# KIRKLEES METROPOLITAN COUNCIL INVESTMENT & REGENERATION SERVICE

Reference No:	<b>2025/44/90352/E</b>
Site Address:	adj, 33a, Church Lane, Clayton West, Huddersfield, HD8 9LY
Description:	Discharge of details reserved by conditions 6 (boundary treatments), 8 (intrusive site investigations and remedial works), 9 (declaration), 10 (Phase I Desk study Report), 11 (Phase II Intrusive Site Investigation Report), 12 (Remediation Strategy), 13 (Remediation Strategy), 14 (Verification Report) and 15 (Arboricultural Method Statement and Tree Protection Plan) of previous permission 2024/93464 for variation condition 2 (plans) on previous permission 2023/91483 for demolition of garage and erection of detached dwelling.
Recommending Officer:	Nina Sayers

#### **DECISION – DISCHARGE OF CONDITIONS – SPLIT DECISION**

## Officer Report

Boundary Treatment Plan

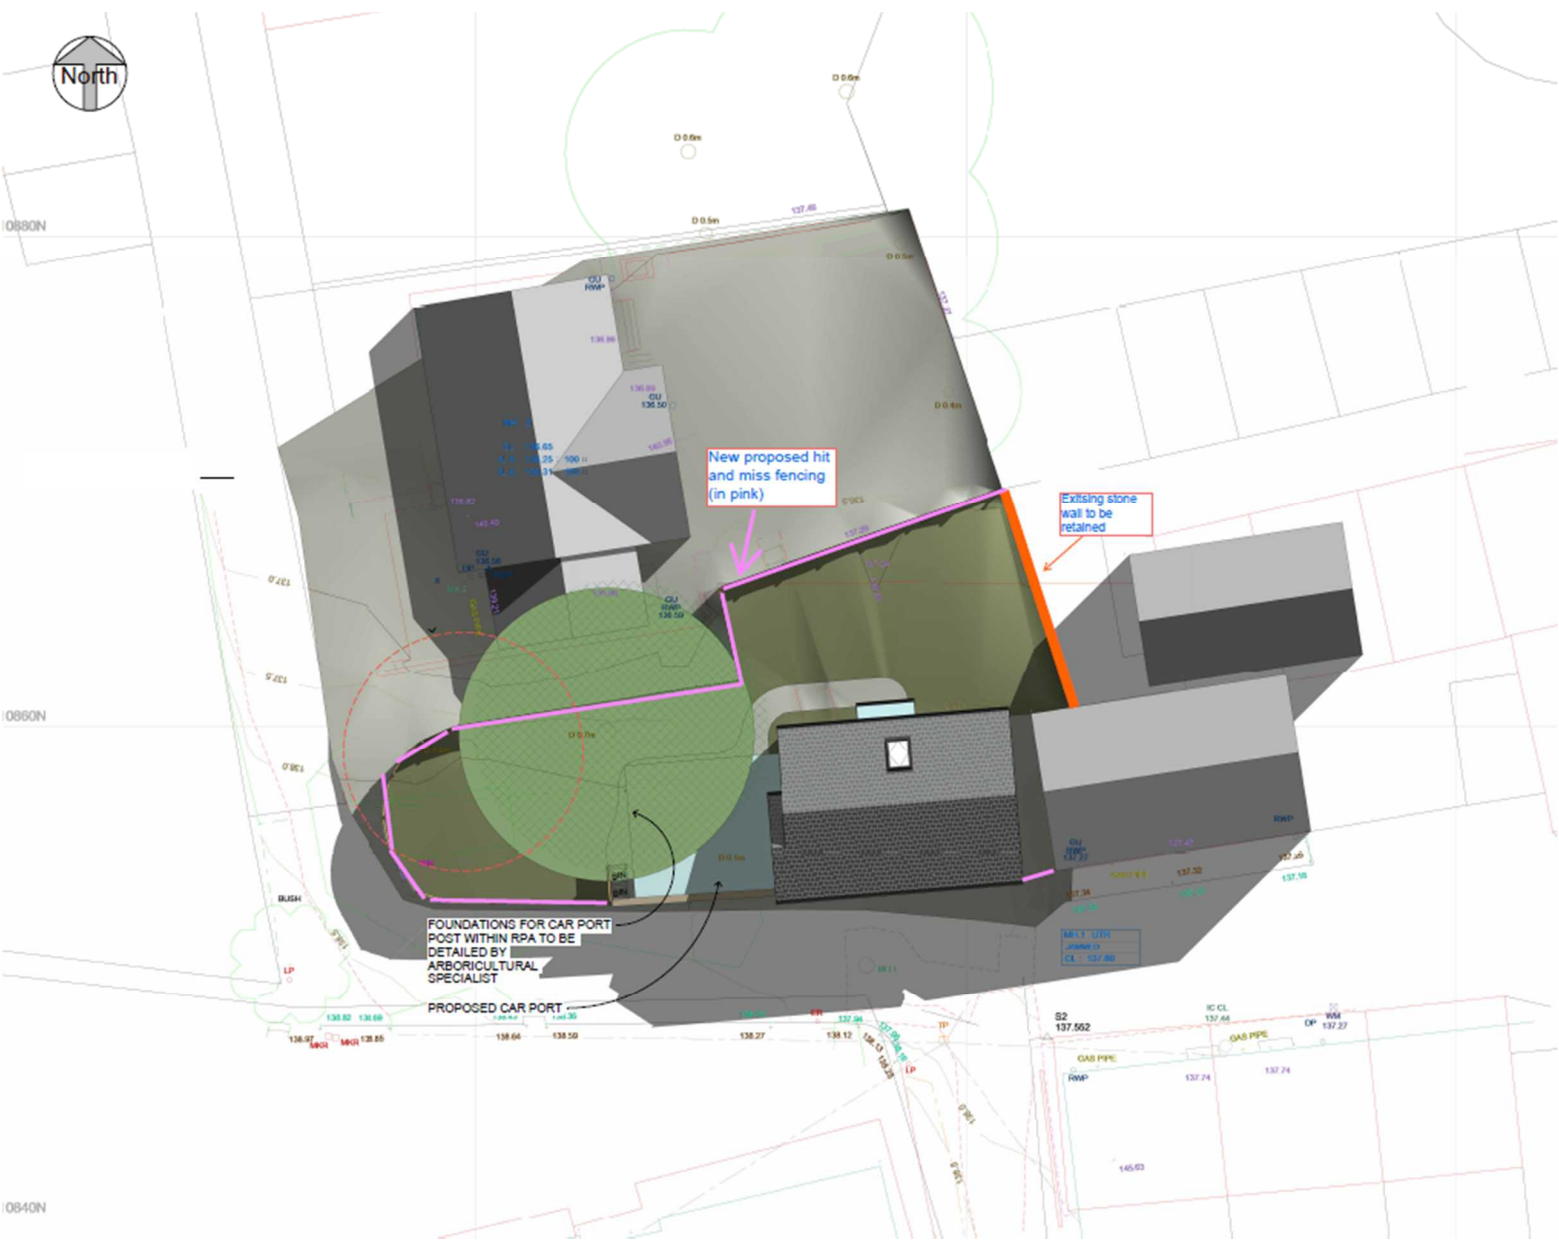
Officers have concerns regarding the height of the proposed fence adjacent to the access with both the parking area for the approved dwelling and the existing access to 33a Church Lane. Officers asked the applicant to demonstrate visibility splays on the plans to demonstrate that this would not interfere with visibility however this has not been provided.

Similar details were submitted and refused under application 2024/93179. The officer report for this application stated “a 1.8m fence adjacent to a vehicular access would not be acceptable as it would raise concerns relating to visibility.”

Condition 6 can therefore not be discharged at this time.
